TRAFFIC IMPACT STUDY

Owl Place Commercial
El Paso County, Colorado
PCD File No. CR221

June 2022
Revised:
January 2023

**Figure 4A**  
**BACKGROUND TRAFFIC - YEAR 2024**  
 Volumes  
 AM / PM Peak Hour  
 (ADT) : Average Daily Traffic

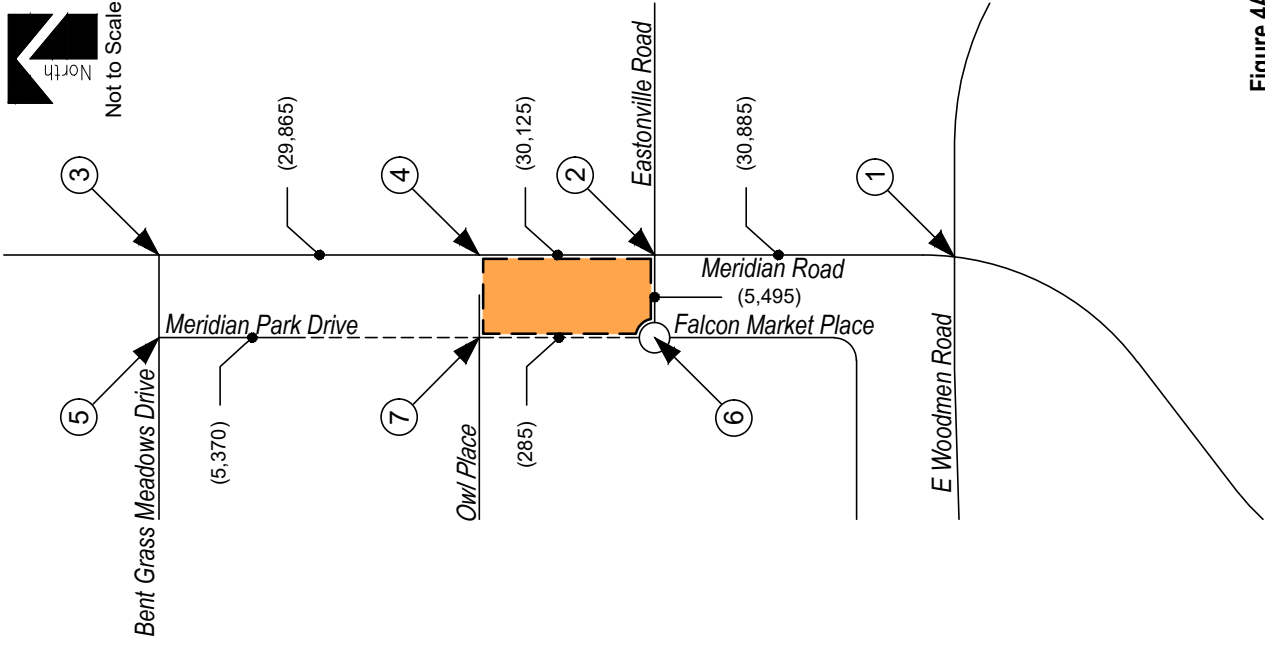
Does not appear to account for traffic from approved Bent Grass east commercial (SP2010 & SF2147) traffic as the TIS for that site indicates +5K trips along meridian park drive.

Noted. Background volumes reassessed pursuant to available reports for adjacent developments.

**Figure 5A**  
**BACKGROUND TRAFFIC - YEAR 2040**  
 Volumes  
 AM / PM Peak Hour  
 (ADT) : Average Daily Traffic

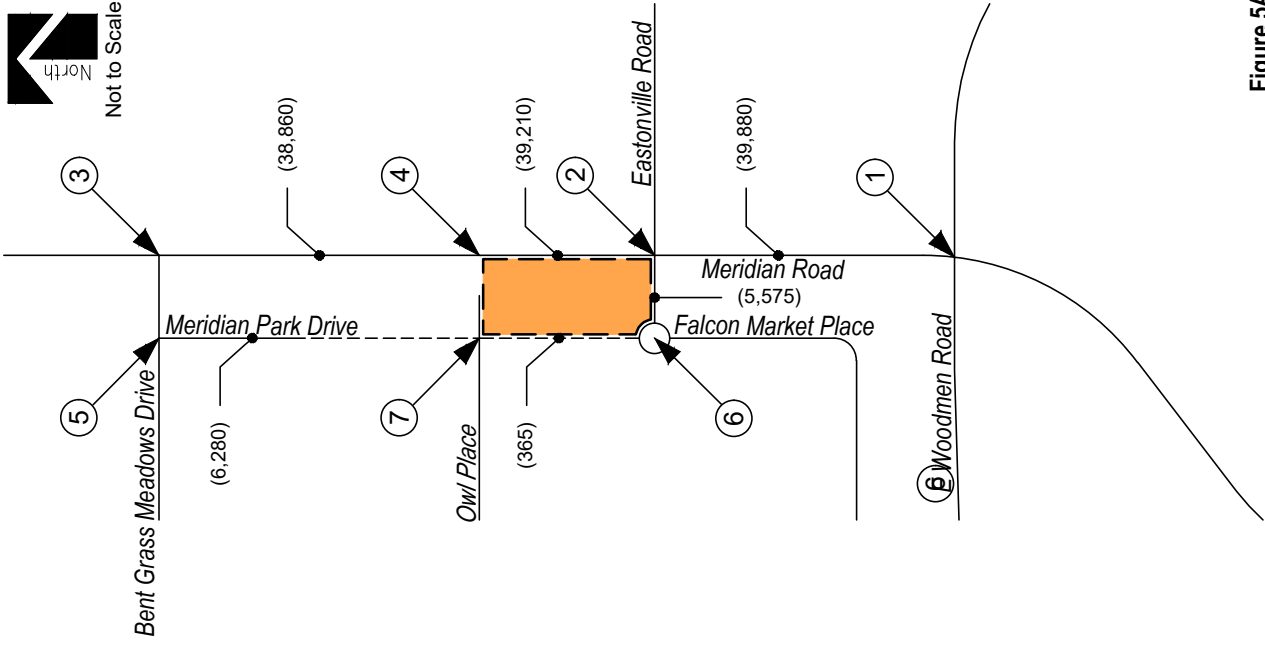
Staff requested analyses with both scenarios where this intersection is closed or RI/RO only. If only one analysis is provided it should be without the RI/RO to address potential effects on the surrounding intersections.

Pursuant to conversation with County Staff, analysis updated to assume closure of Owl place by short-term background conditions in order to present the worst-case scenario.

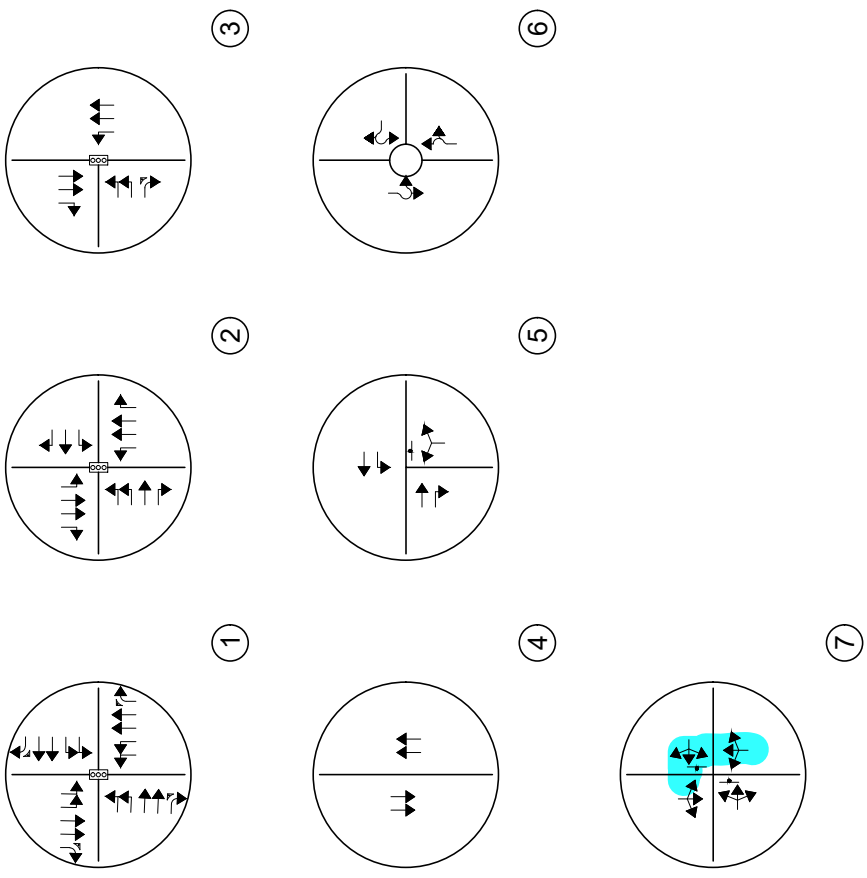
Provide link ADT here on all figures
 ADT added.
